***TRANSITIONAL PART 3A PROJECT
ASSESSMENT:
North West Precinct Redevelopment
Royal Prince Alfred Hospital
(MP 10_0166)***

Director-General's
Environmental Assessment Report
Section 75I of the
Environmental Planning and Assessment Act 1979

February 2013

DEPARTMENT OF PLANNING SUBMISSION
LOWER GROUND LEVEL PLAN

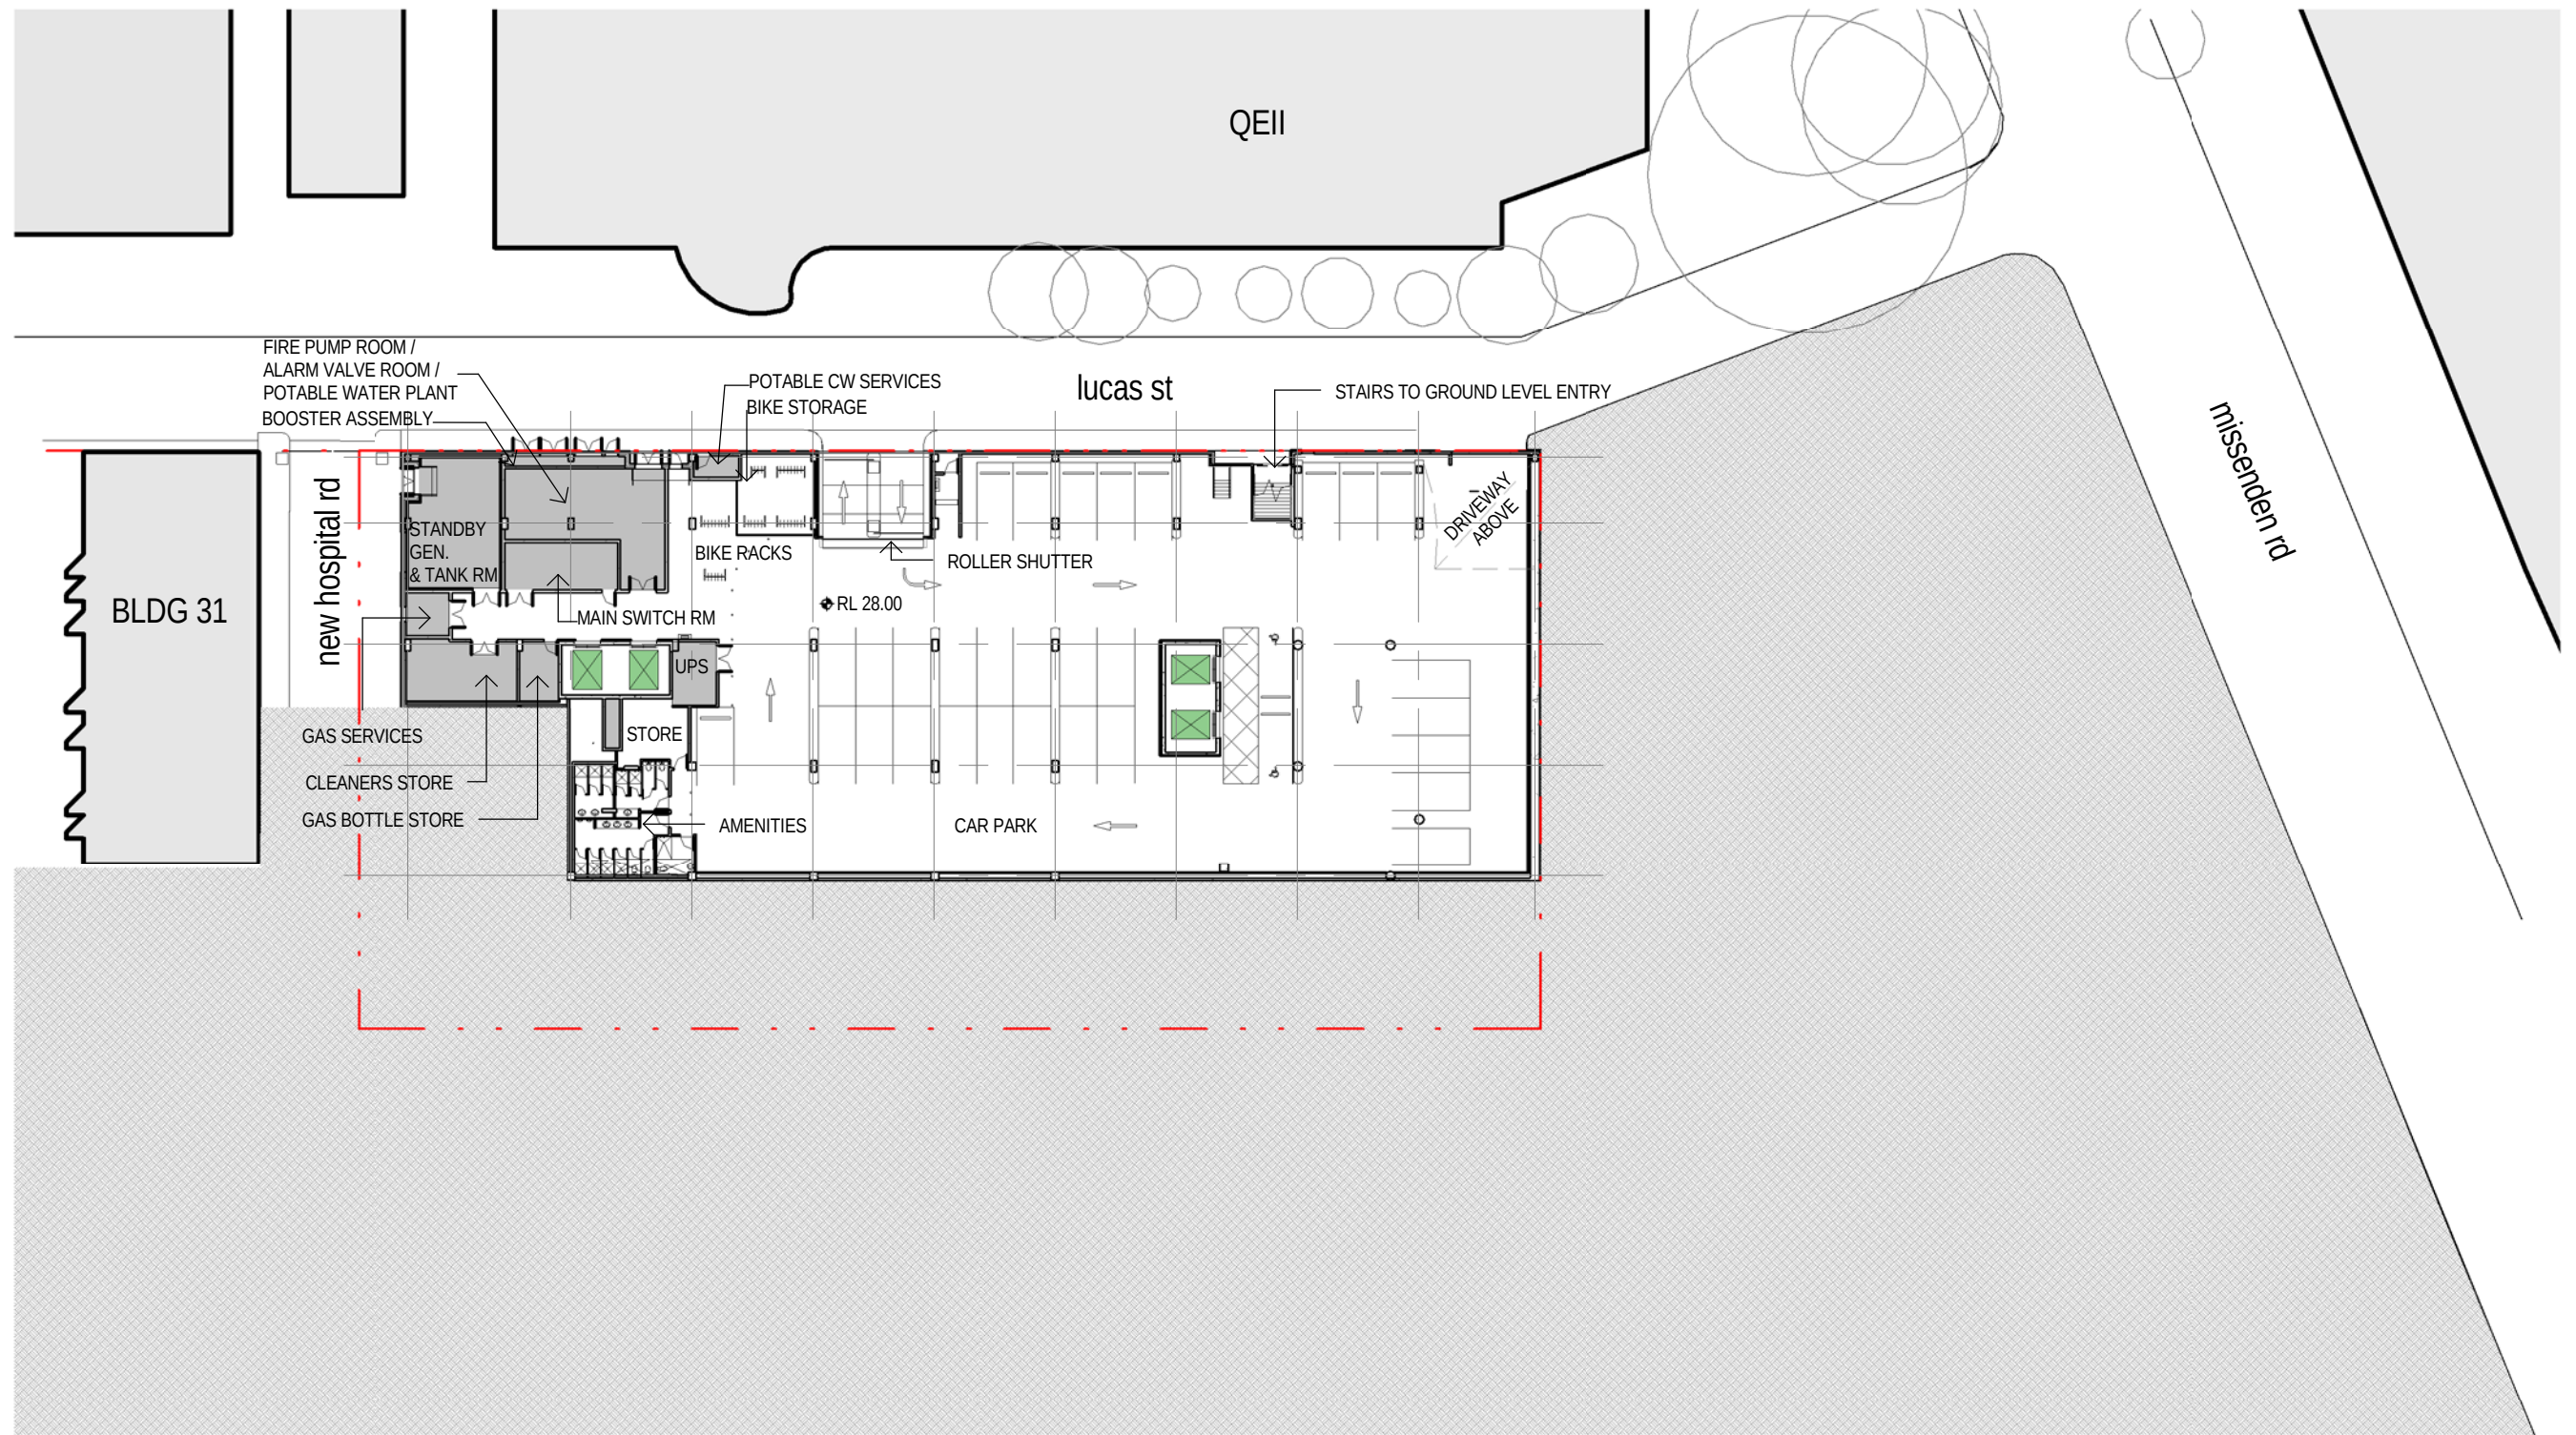
The department and council raised concern with the location and the design of the proposed loading dock in the original EA as it required large service vehicles exiting the site to undertake multiple point turns to exit in a forward direction via New Hospital Road, which connects to Lucas Street. The proponent has subsequently demonstrated in the PPR that vehicles would be able to leave in a forward direction via New Hospital Road and Grose Street. The department notes that vehicles would still need to reverse into the loading dock and this is considered acceptable as this is confined to large vehicles which would have reversing vehicle alarms.

GROUND LEVEL PLAN

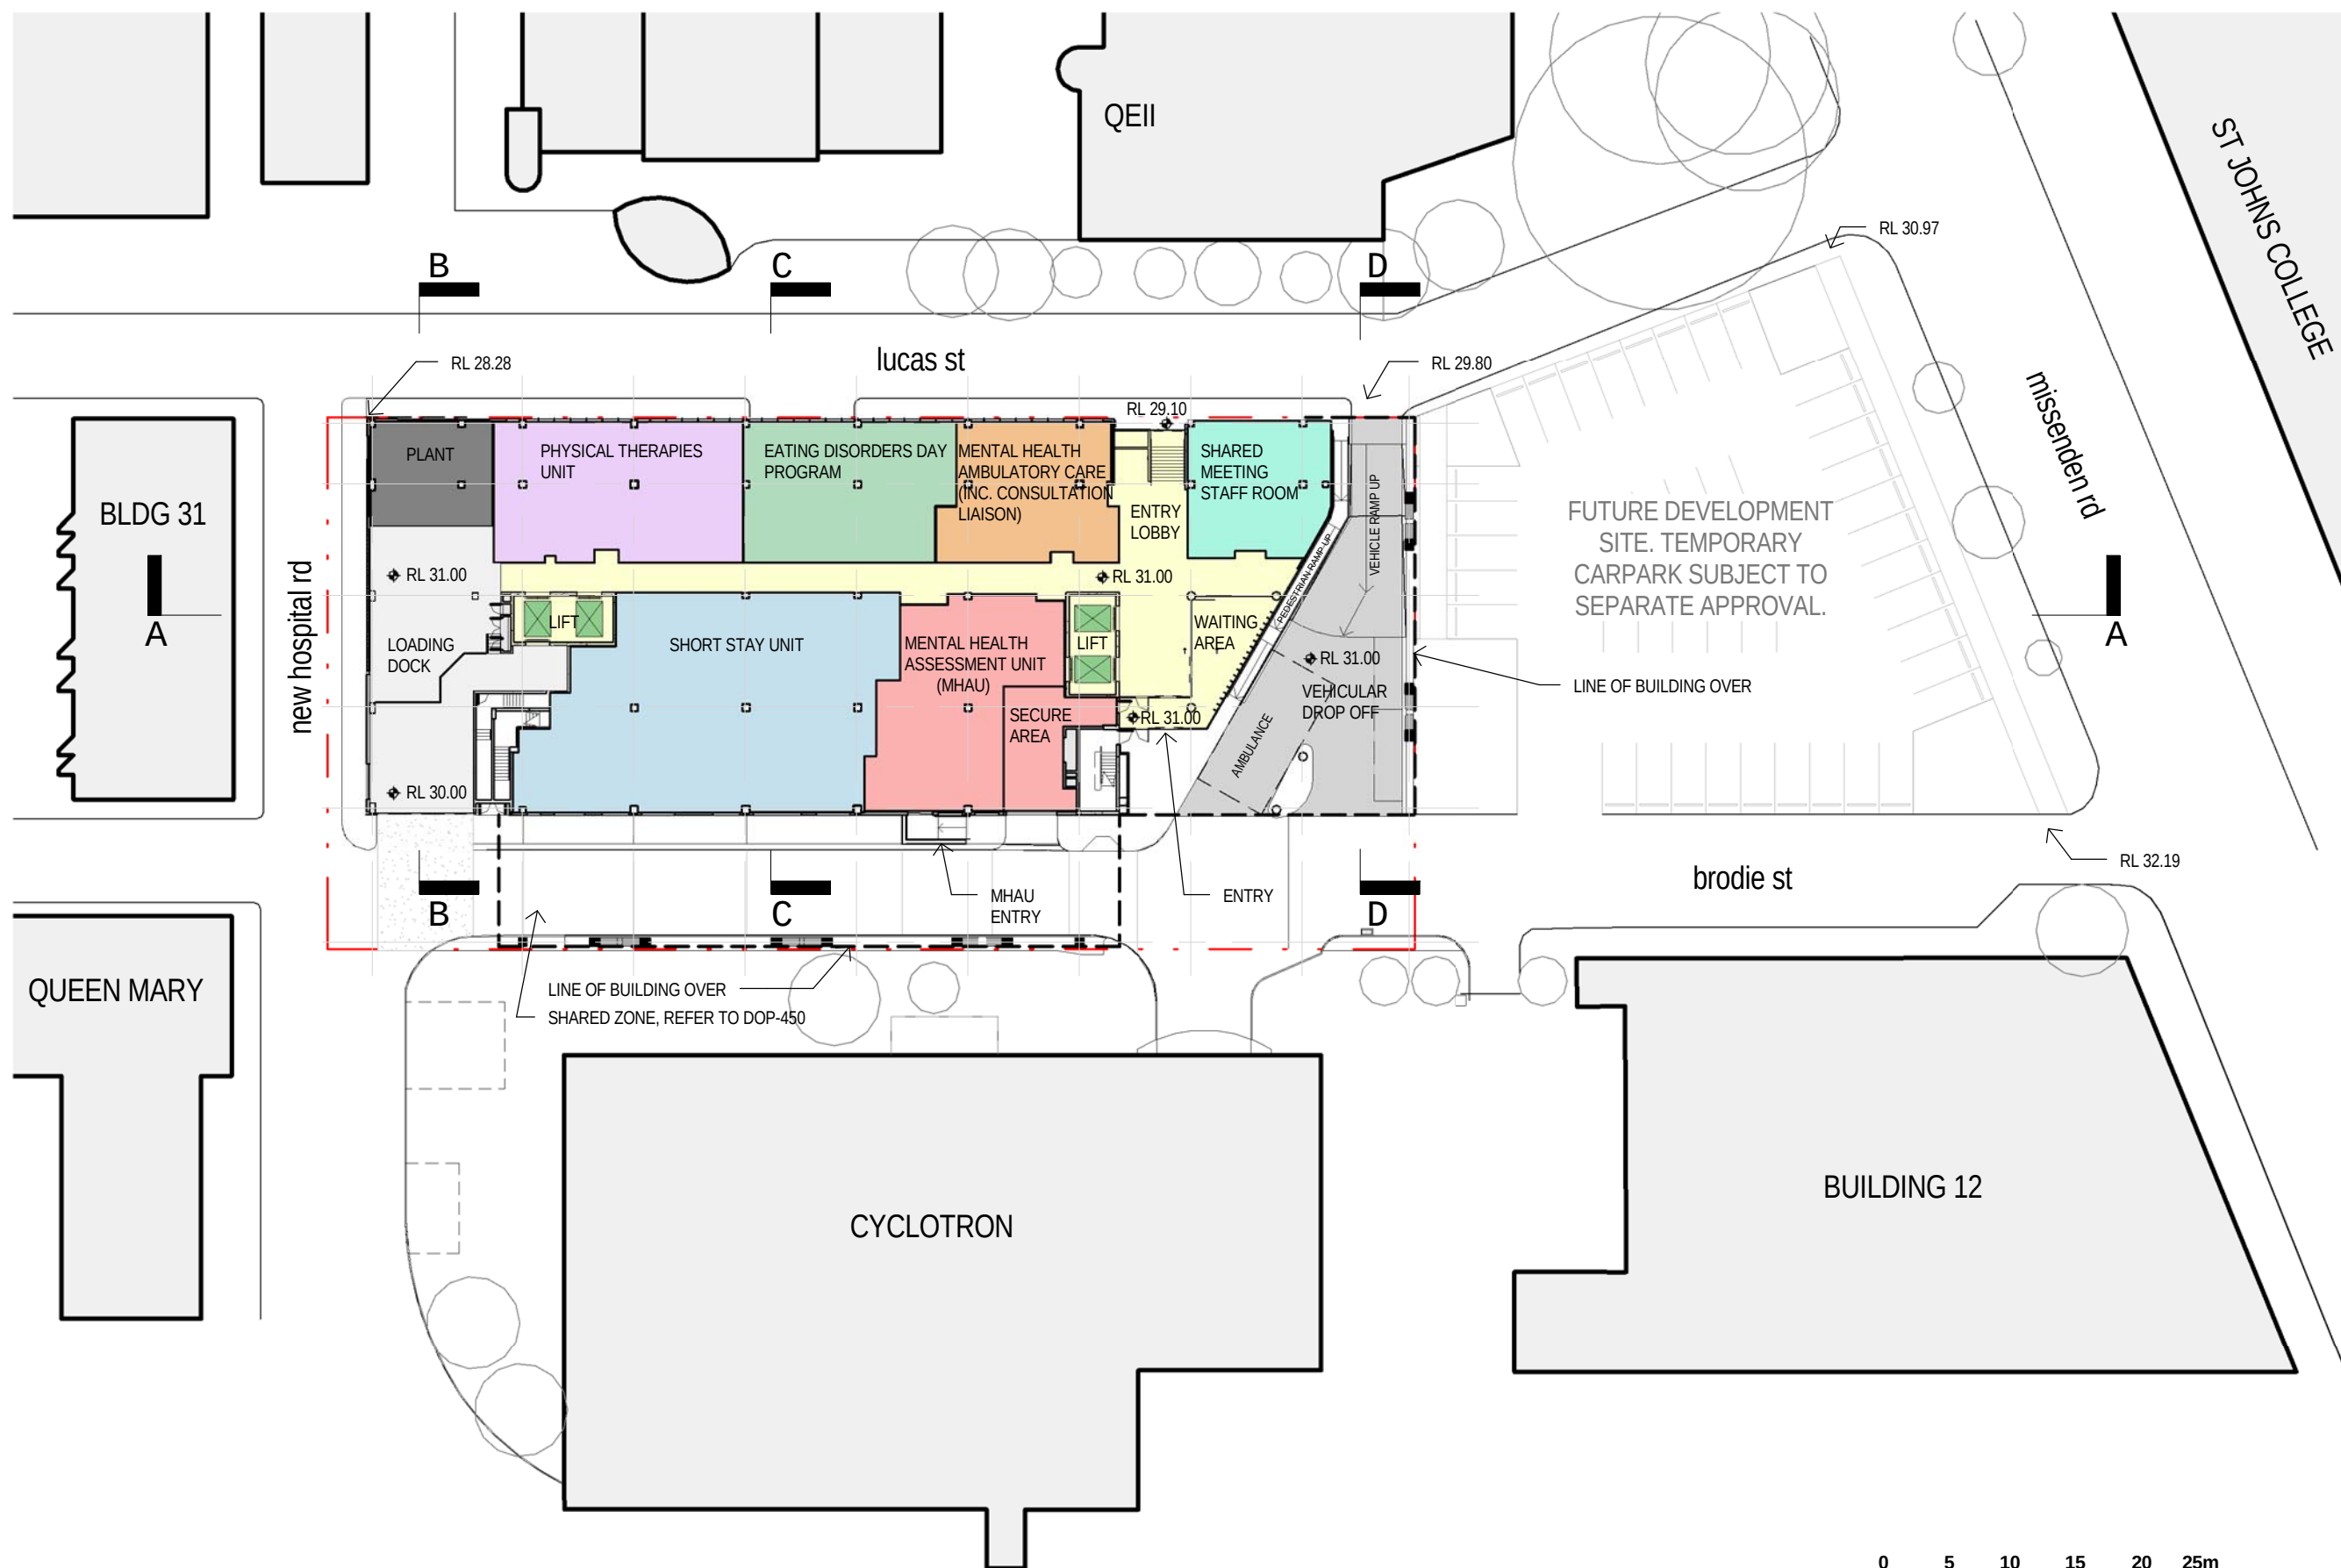
- the design should incorporate greater street activation and modulation along the Lucas Street elevation, including providing a public entrance along this frontage;

- the design should provide greater transparency along Brodie Street to improve casual surveillance;
- greater consideration of CPTED in the design including activation of the public domain at street level;

- the shared zone requires approval from the local traffic committee;
- the design needs to be revised to ensure no development encroaches the public domain, i.e. the service doors and landscaping;

- a new secondary building entry off Lucas Street;
- improved pedestrian entry off Broadie Street, including greater activation and transparency;
- internal floor layout modifications to improve amenity for patients and staff;
- modified building materials and facade design;
- landscape plan;
- design of the shared zone; and
- reduction in off-street car parking by six spaces (from 38 to 32).
